Client E. DALTON	
Project Leather Hall Barn, Honley.	
Drawing Proposed redevelopment of existing stable to form granny flat	
Number 4378-05-01c	Checked Scale @ A1 as marked
Date 11/2021

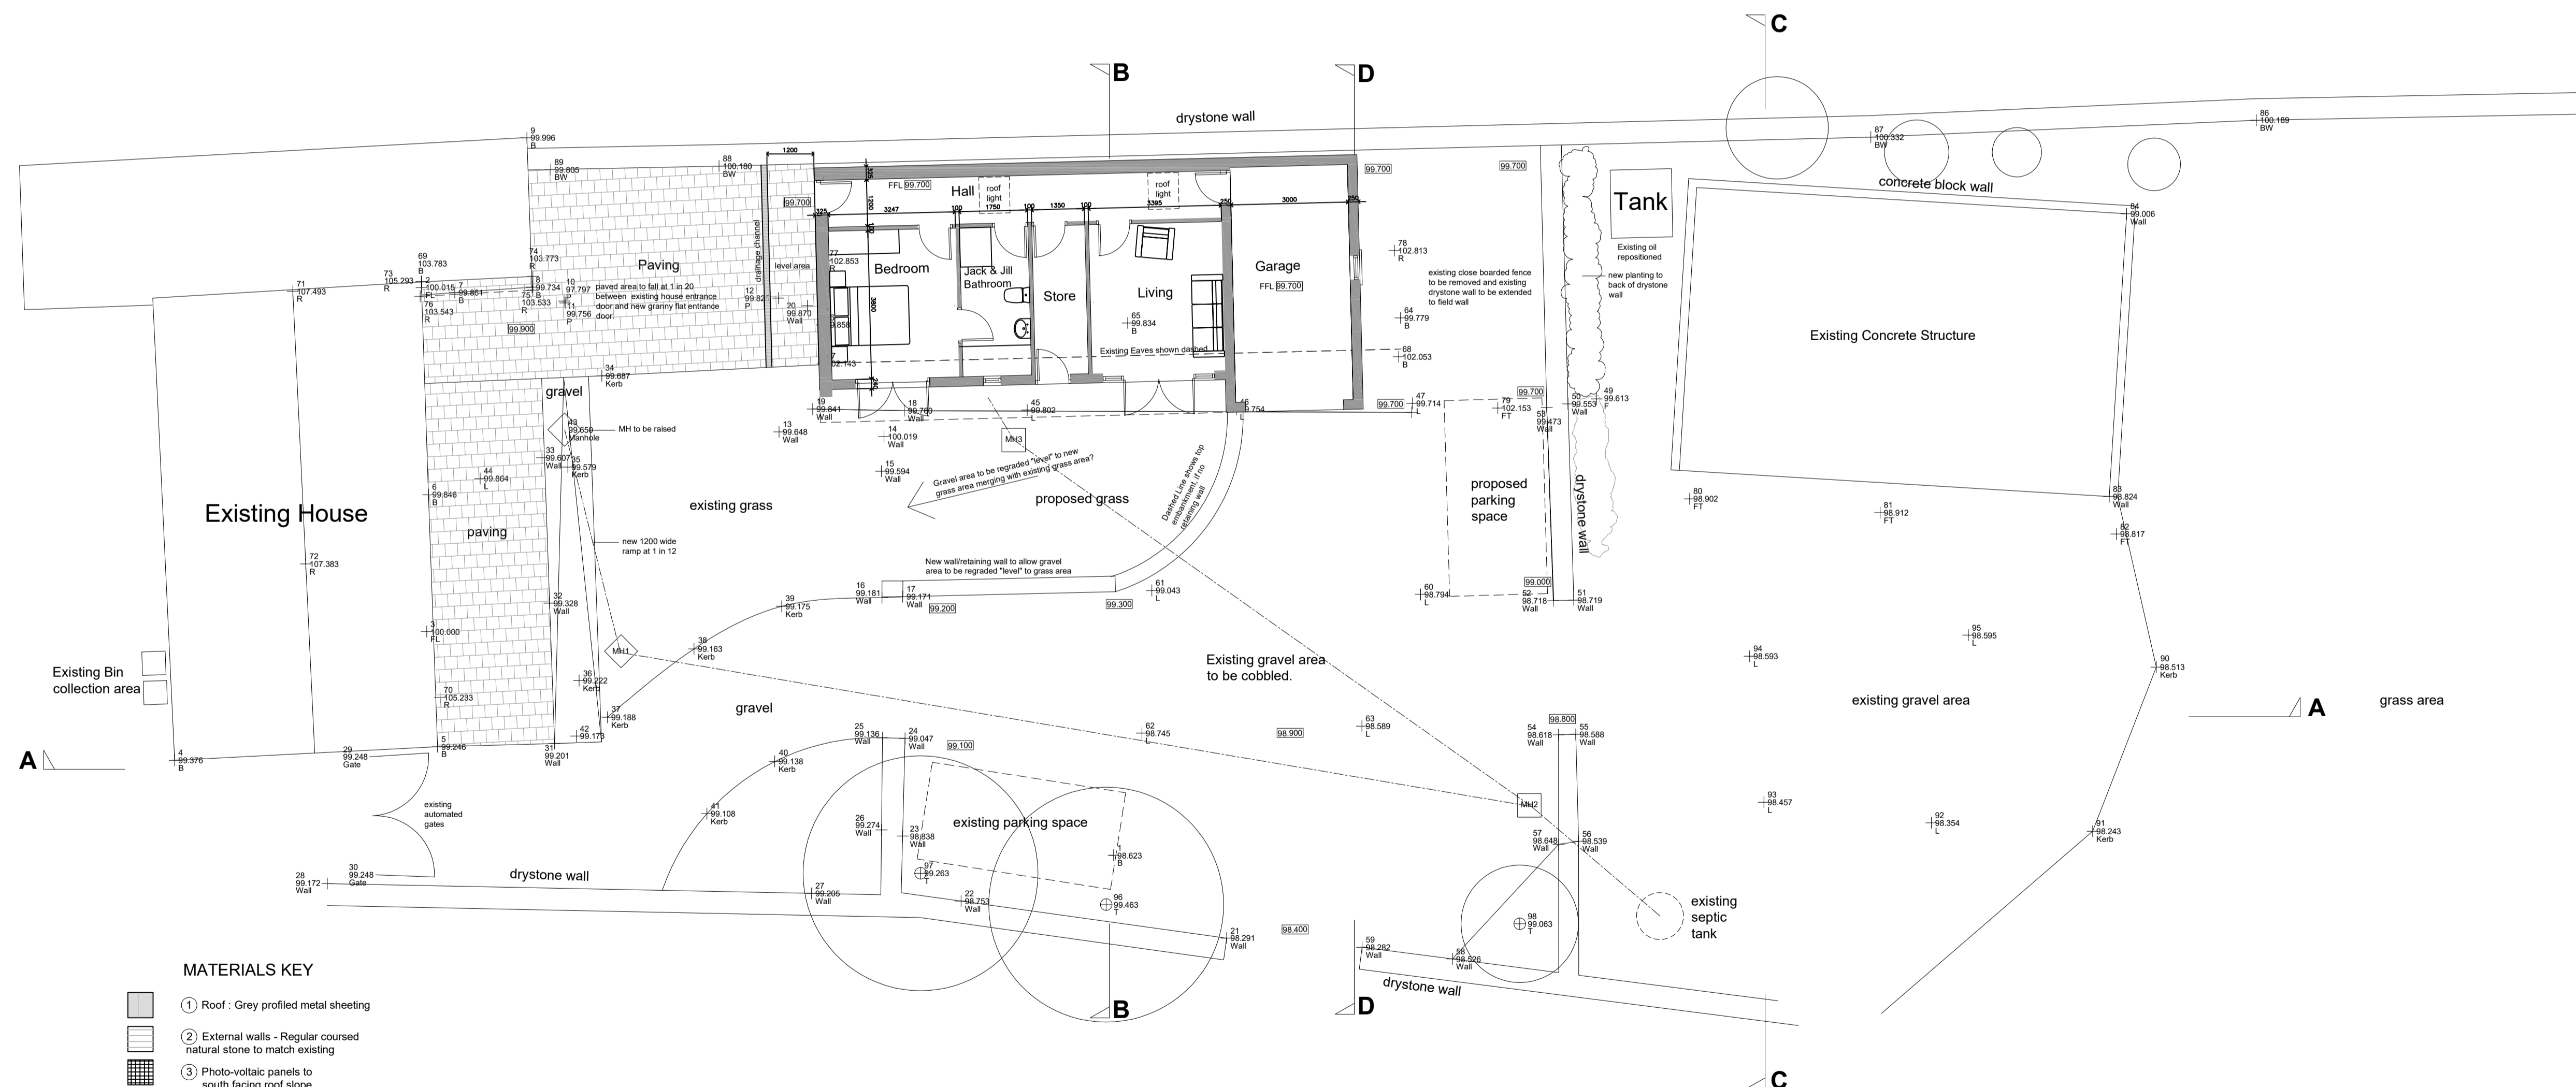
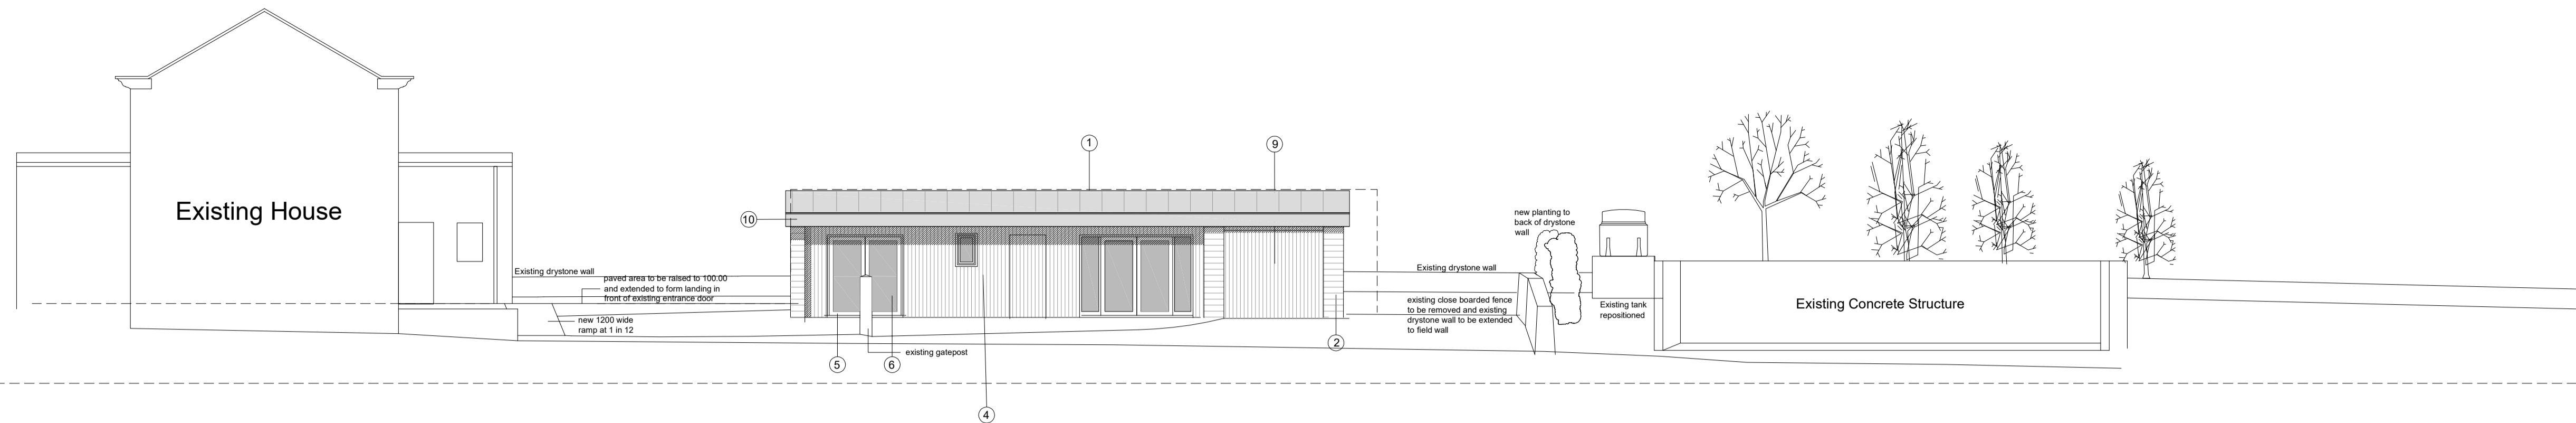
3.8m giving a footprint of 56m². By contrast the floor area of the proposed annex measures approximately 15m x 6.0m giving a footprint of 90m². This is an increase of 34m². The footprint of the proposed development therefore exceeds the footprint of the existing development, which is contrary to Policy LP59. Furthermore, the height of the building proposed would be increased from 3.1m to 3.5m. This, along with the increase in footprint, would result in a building with a much greater volume than the existing.

The proposed plans show that the annex would comprise of one bedroom, one bathroom, a store, a living room and an integral garage. However, the size and the location of the store adjacent to the living room, suggests this could easily be converted into a kitchen. If the store is genuinely proposed to be a store, why is there a need for an internal door? The same could be said of the integral garage. The applicant claims the garage would be used by the applicant and would not be for grandparents staying in the annex. ³ Again, if this is the case, why the need for an internal door?

Given the ambiguity regarding the type of accommodation proposed within the annex, our clients are concerned that the annex would not be used as ancillary residential accommodation for the enjoyment of the main house but would instead be used as separate primary living accommodation. Should the store be converted into a kitchen, the proposed annex would be fully self-contained providing all of
